**Our Case Number:** ABP-314724-22

**Re:** Railway (Metrolink - Estuary to Charlemont via Dublin Airport) Order [2022]  
Metrolink. Estuary through Swords, Dublin Airport, Ballymun, Glasnevin and City Centre to  
Charlemont, Co. Dublin

I would like to lodge the following submission in relation to the Metrolink project.

ALBERT COLLEGE PARK INTERVENTION SHAFT. PLAN
SCALE 1:400

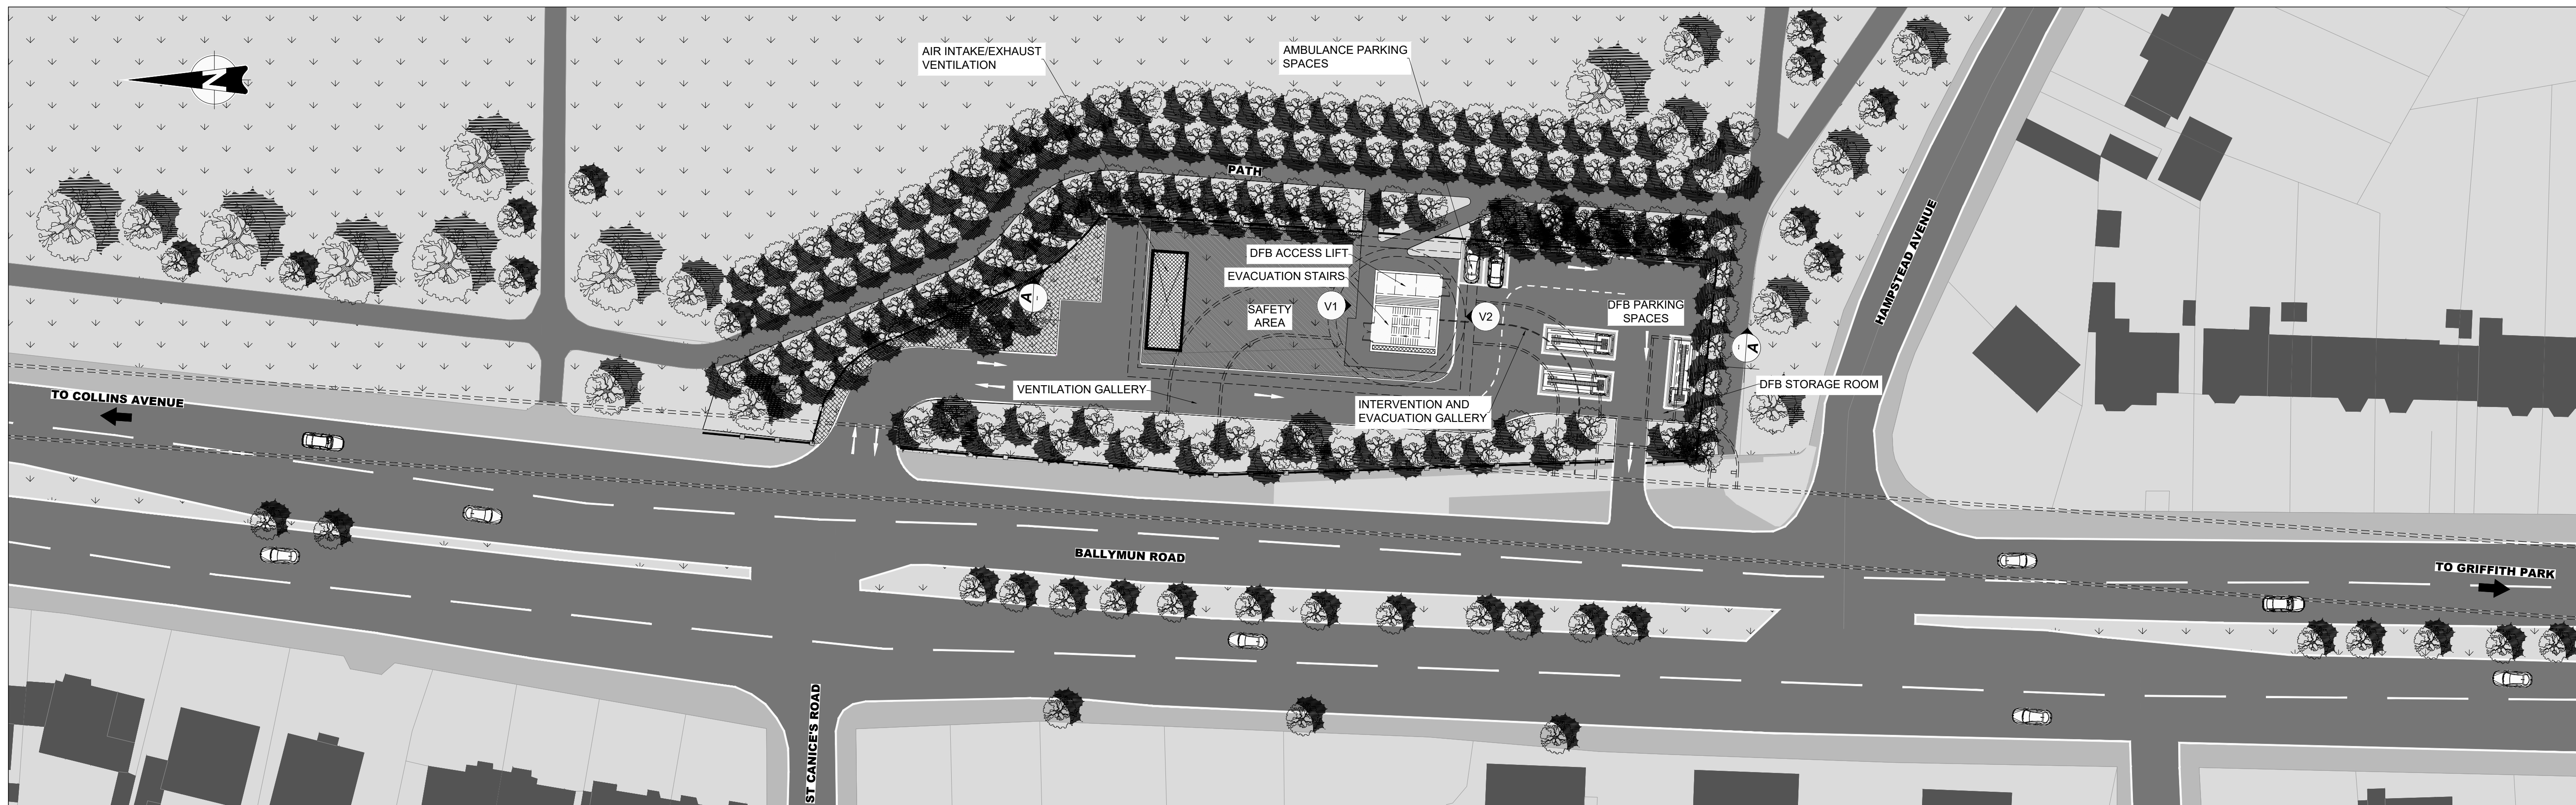
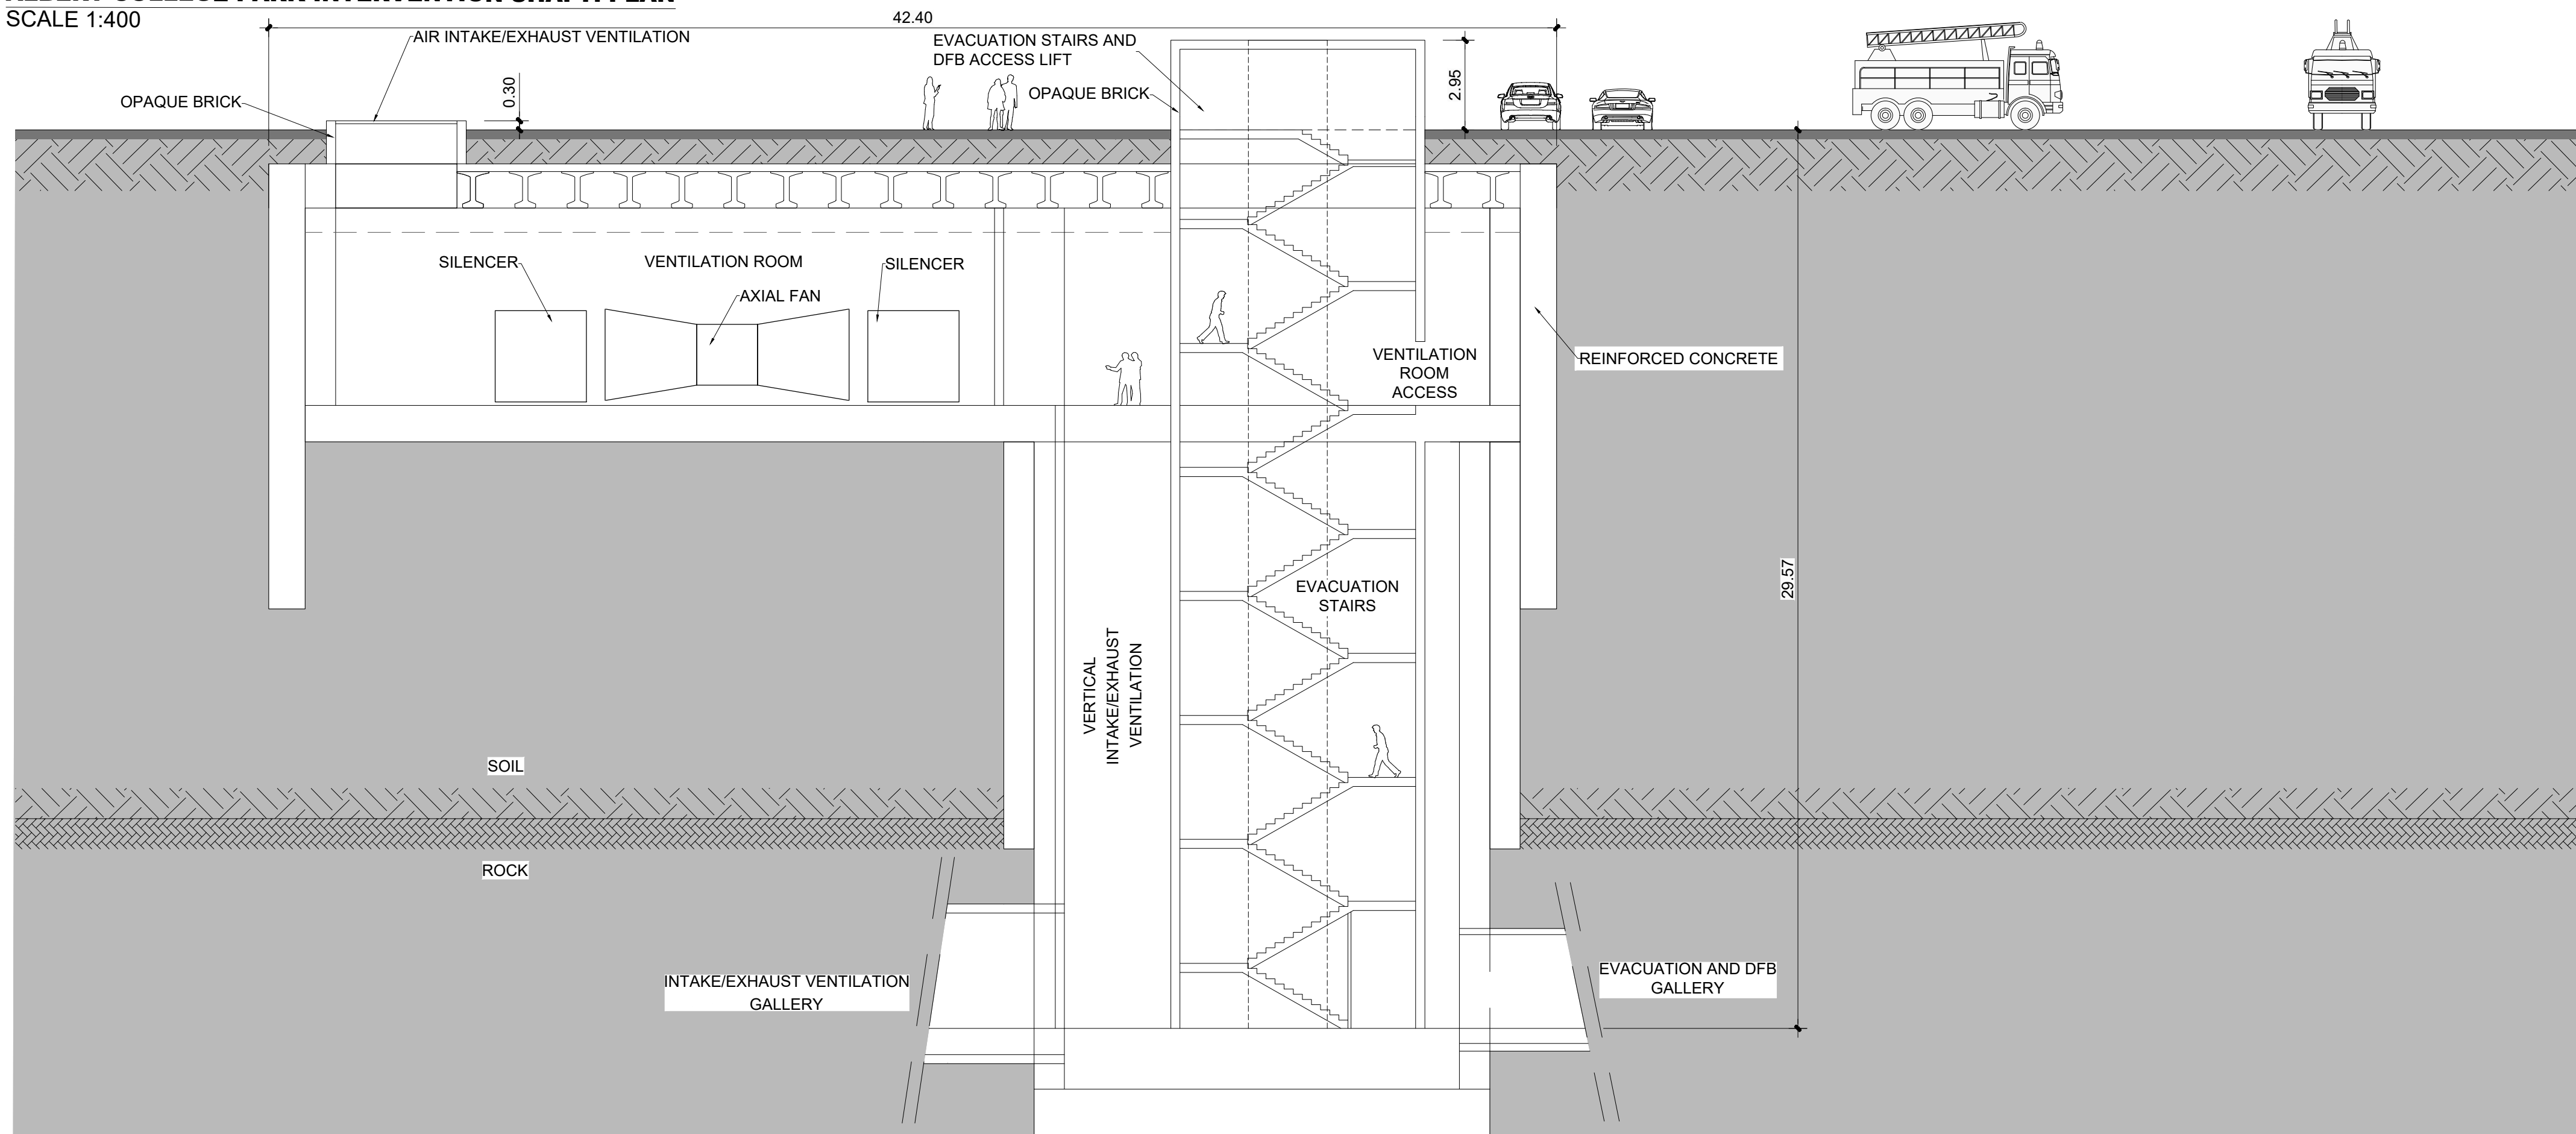
There is a lack of information on the proposed shaft in Albert College Park and its potential impact on the environs. There are no definite dimensions or detailed studies on the impact of noise, and residents have also questioned the consultation on this element of the project given it was only needed after changes to the nearby Griffith Park station which warranted a shaft. A hand drawn version of the shaft was provided to residents in 2019, just two days before the deadline on the preferred route. There was a very brief consultation on the shaft in 2020, but that again lacked detailed information.
